**Subject:** Objection - Land at, Highmoor Lane, Hartshead Moor, Cleckheaton, BD19 6LW - 2025/62/91542/E

I am writing in reference to the above mentioned planning application.

DRAWING TITLE
Proposed Site Layout

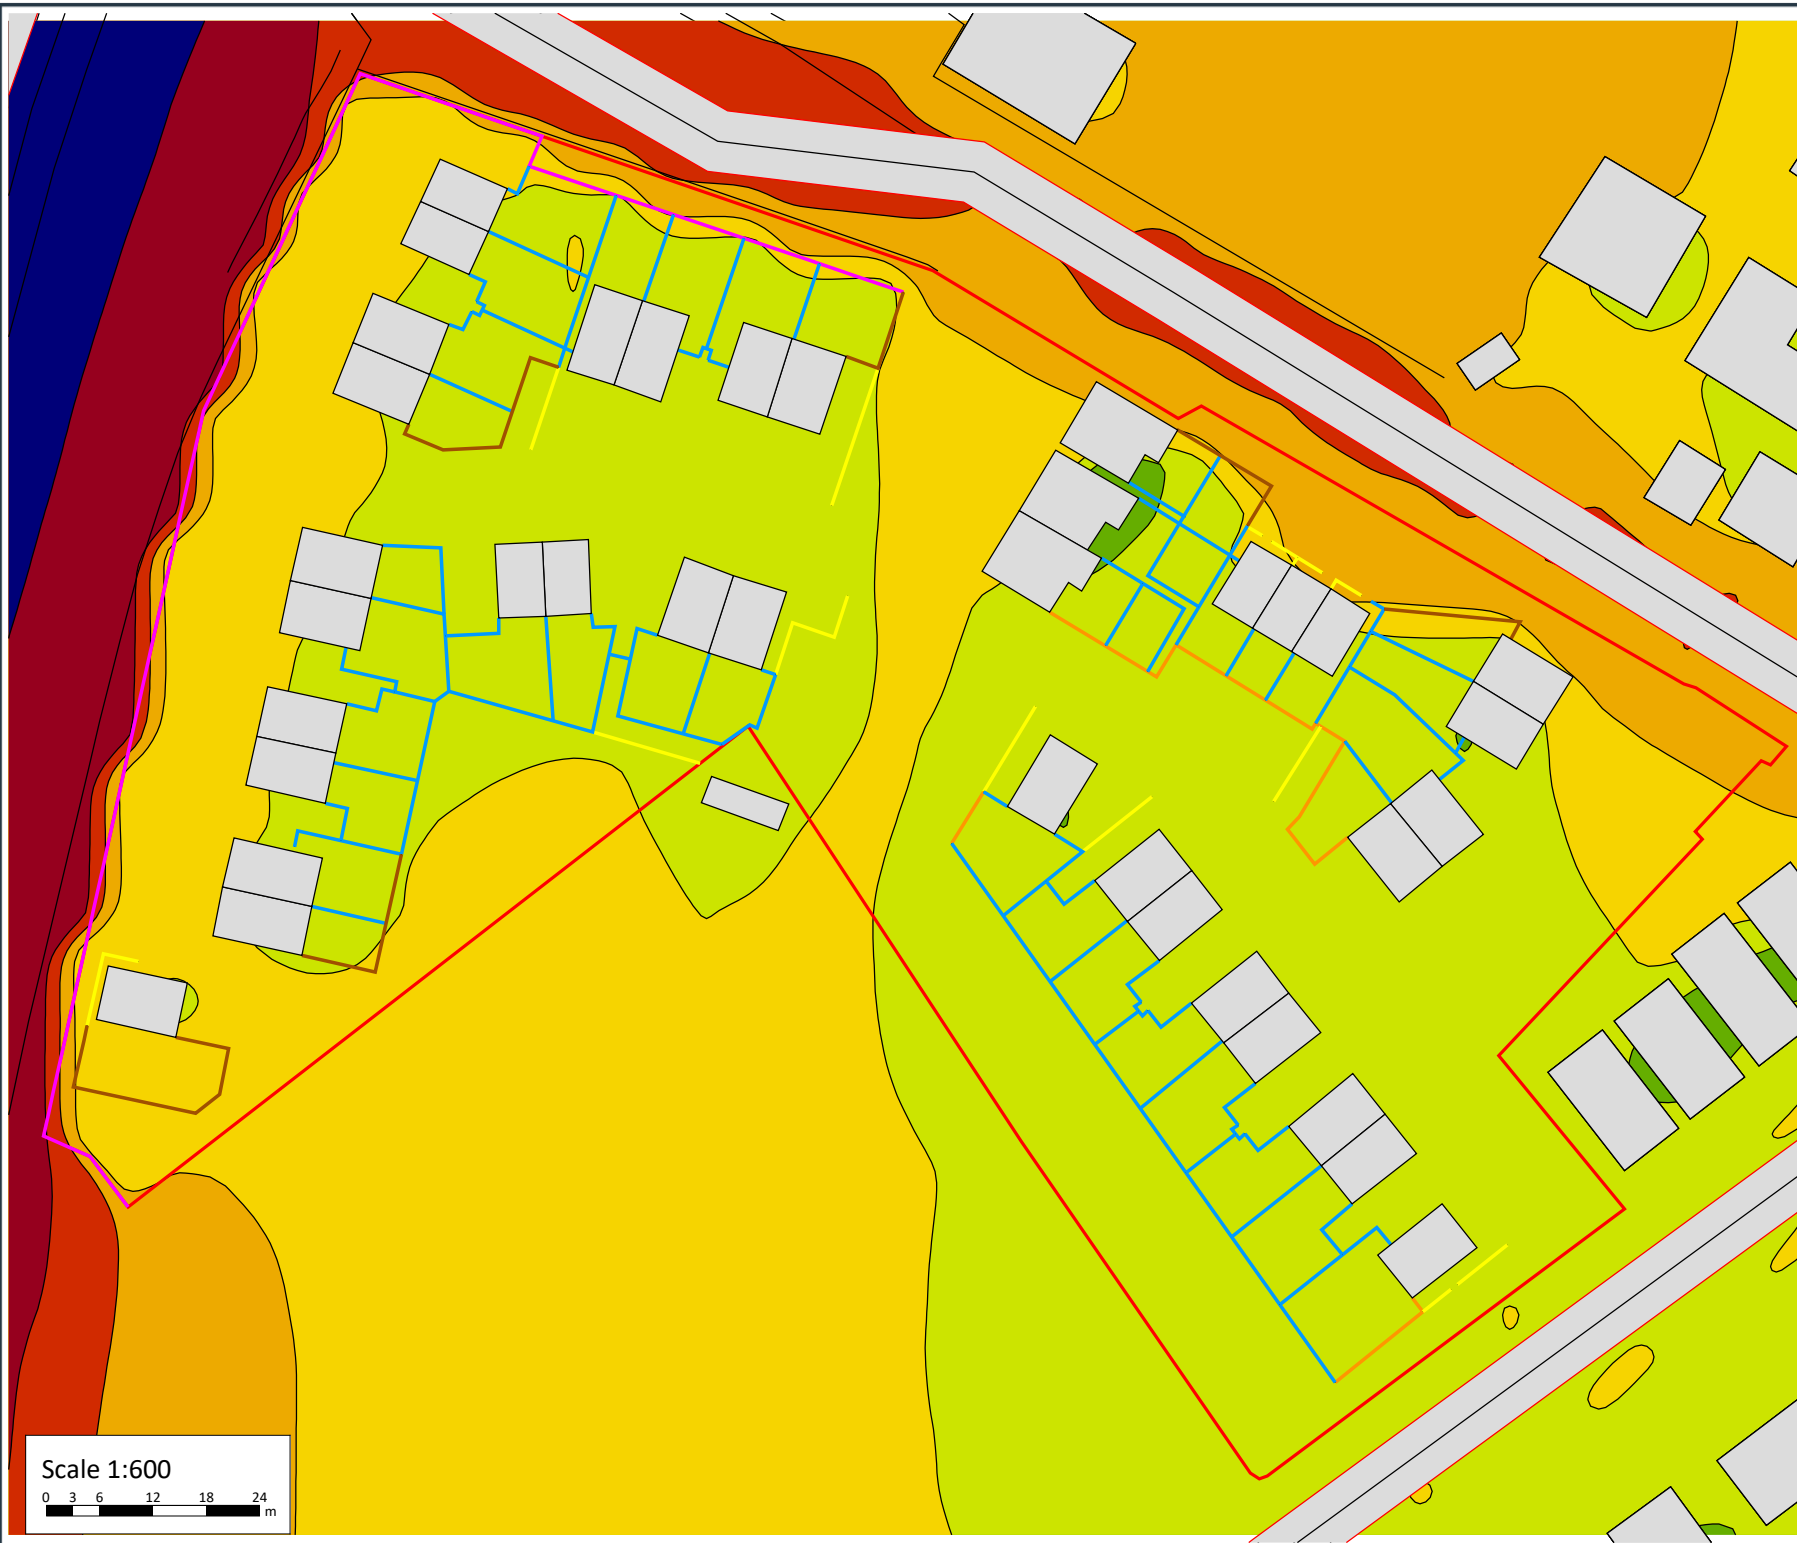
Please find attached an amended version of the drawing in 3.1.1 to illustrate potential amendments to the plan, to accommodate vehicle access from Halifax Road as an alternative to Highmoor Lane. If the amendments are considered, the development which is proposed to retain all but two trees protected by TPOs, one of these to be removed to facilitate the proposed vehicle access point from Highmoor Lane. If the vehicular access route is relocated, this removes the requirement to remove one of these trees, further maintaining the ecology of the site.

Moreover, if the amendments to vehicle access in the 3.3.1 amendment are considered, and there is a specific requirement for a cul-de-sac road layout on the new development, with minor adjustments, this could still be achieved. The access point off Highmoor Lane would accommodate pedestrians only, and not a route for vehicular traffic.

proposed vehicle access point to be located on Highmoor Lane and not Halifax Road. Therefore, I urge the Thirteen Group, along with their Architects and the Kirklees Council Planning Authority to review the points above and re-locate the vehicle access point to Halifax Road and use Highmoor Lane for pedestrian access only, thus maintaining the integrity of the lane for future generations and existing residents and the new ones on the development.
